## Changes to project re \*\*\*ISSUED Building Permit - 35 Industrial Way

Mike Rankin just sent in this email informing us that they made the following changes:

Permit 2017-01971 has been issued by the Permitting and Inspections Department. Attached is an electronic copy of your permit with the "conditions of approval" from each plan reviewer, and construction documents.

A1-0

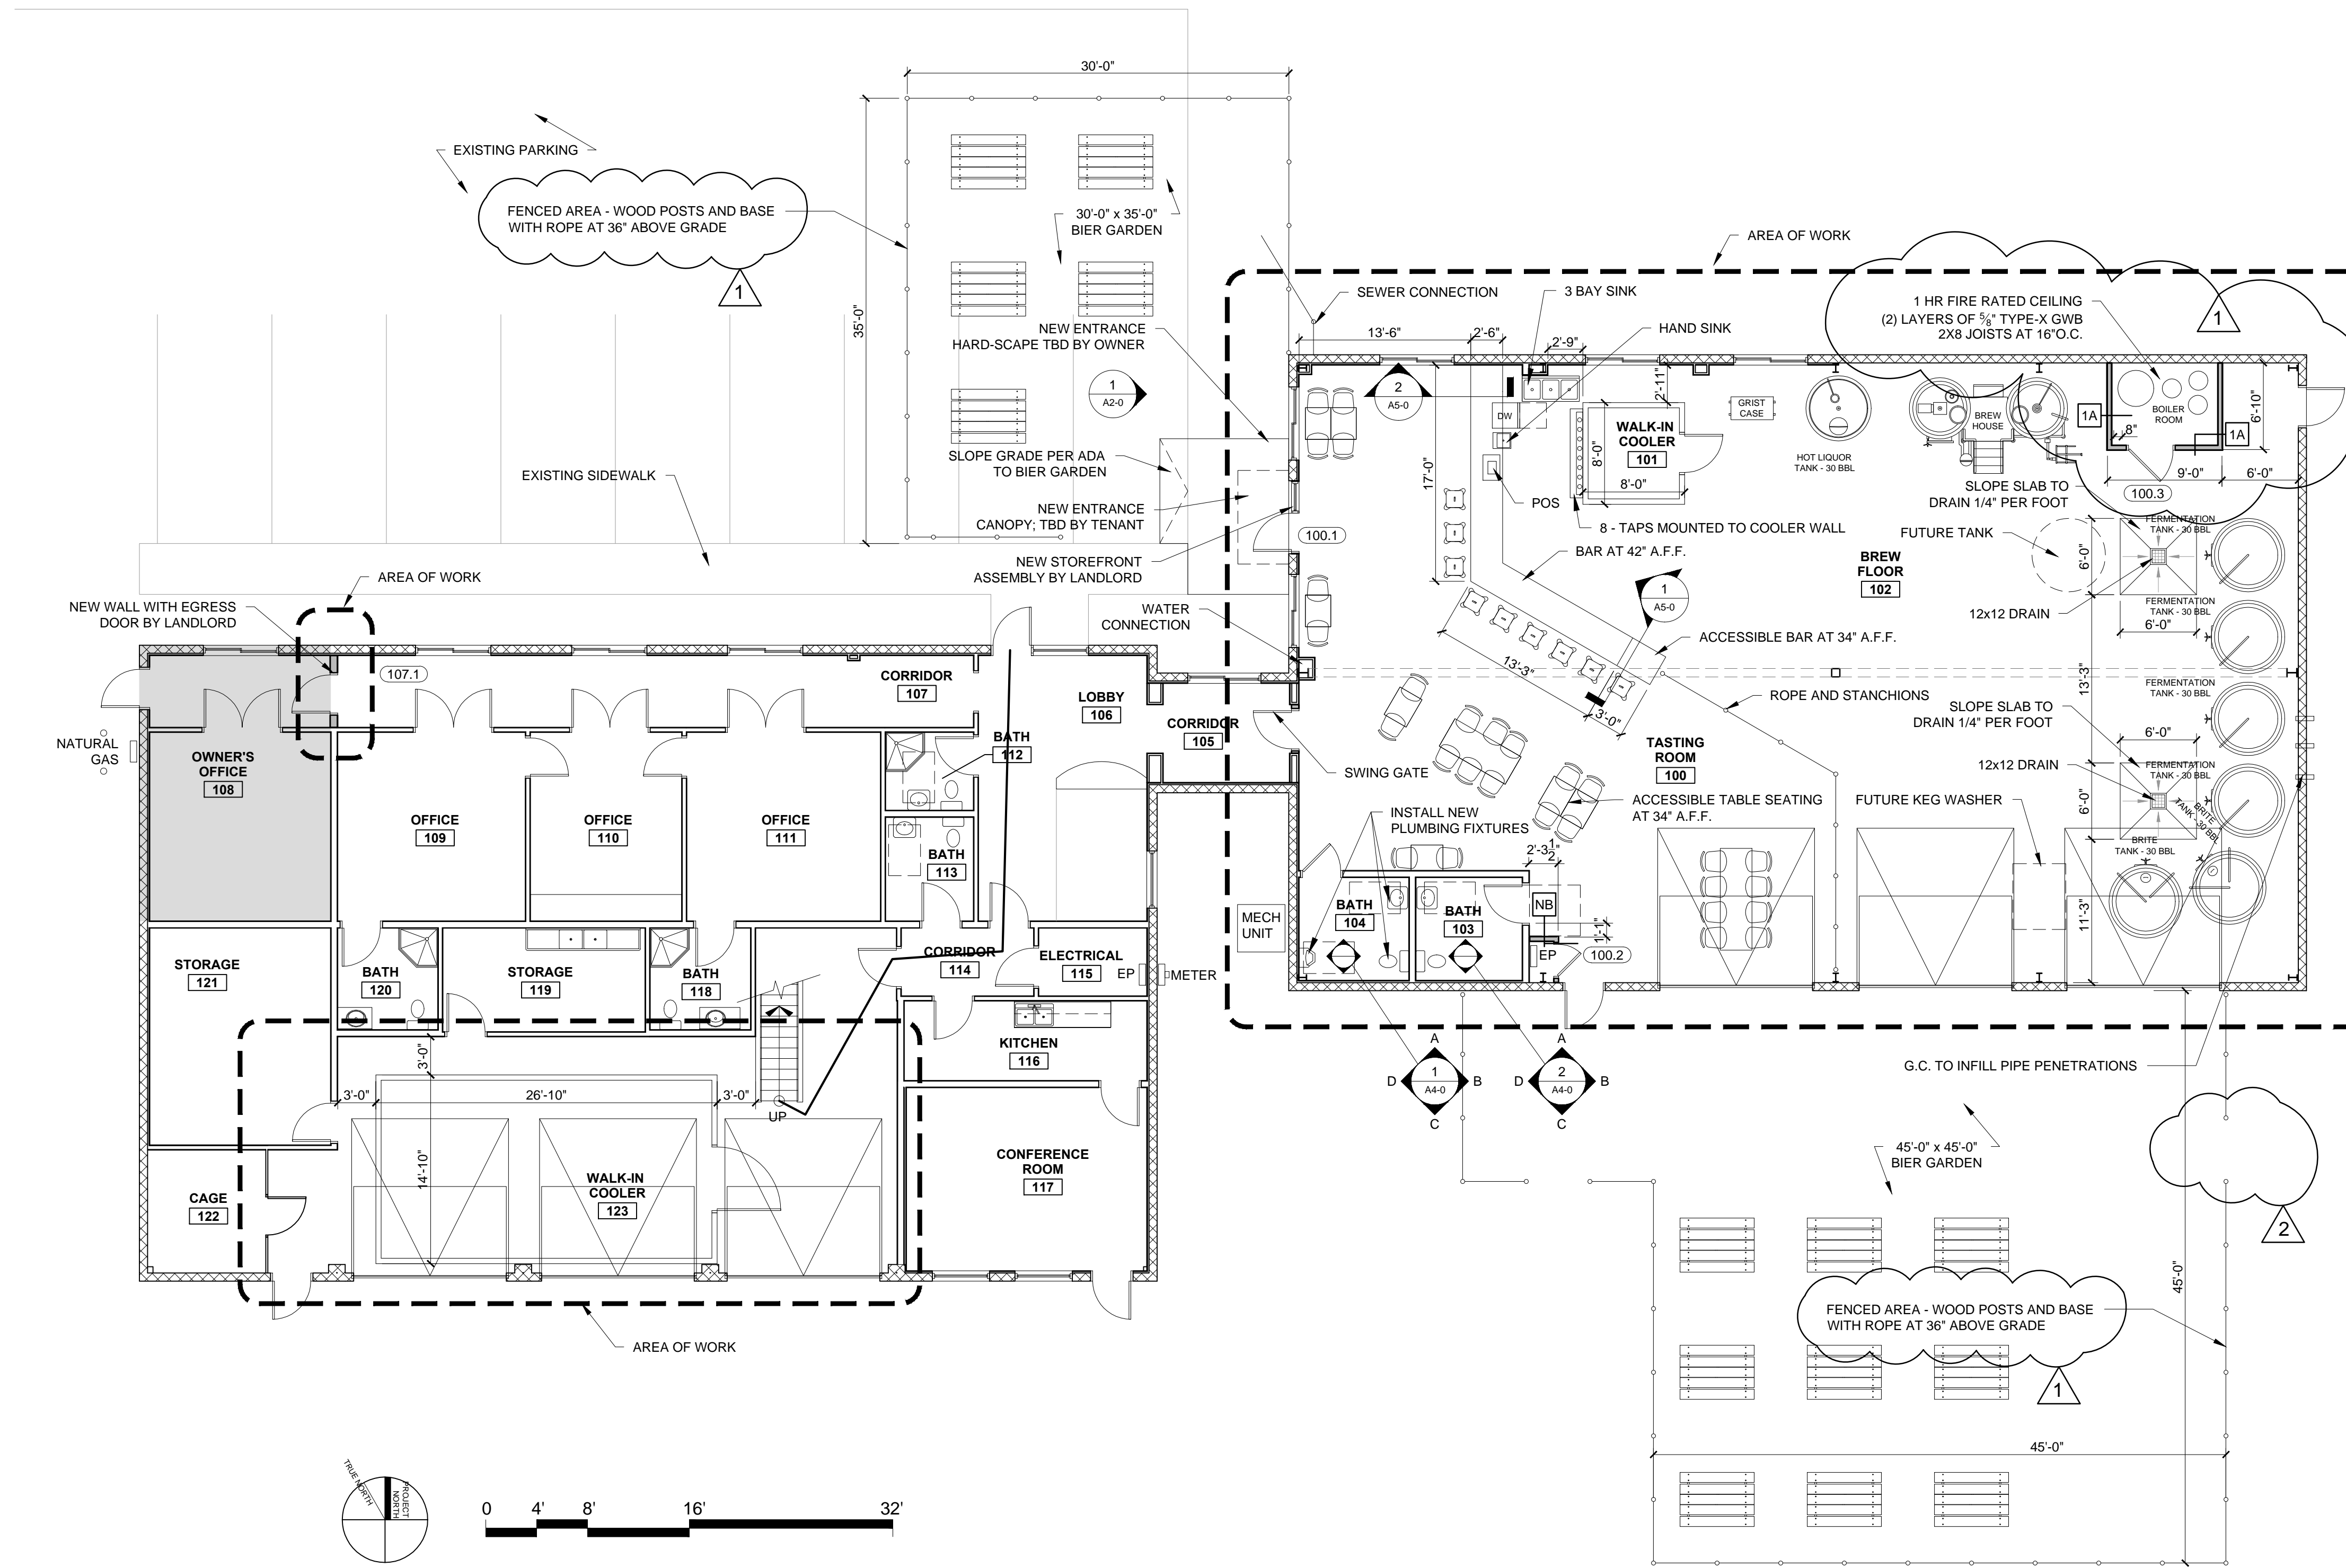
- 1. The boiler room has been changed from 8'x6' to 8'x8' at the recommendation of the plumbing contractor. The updated plans highlight that egress is still sufficient.**
- 2. The walk in cooler in the tasting room area will be 8'x12' rather than 8'x8'.**
- 3. The brewhouse and hot liquor tank have been pulled away from the wall and side of the boiler room at least 3ft to provide safer access on all sides of the equipment and their respective electrical components.**
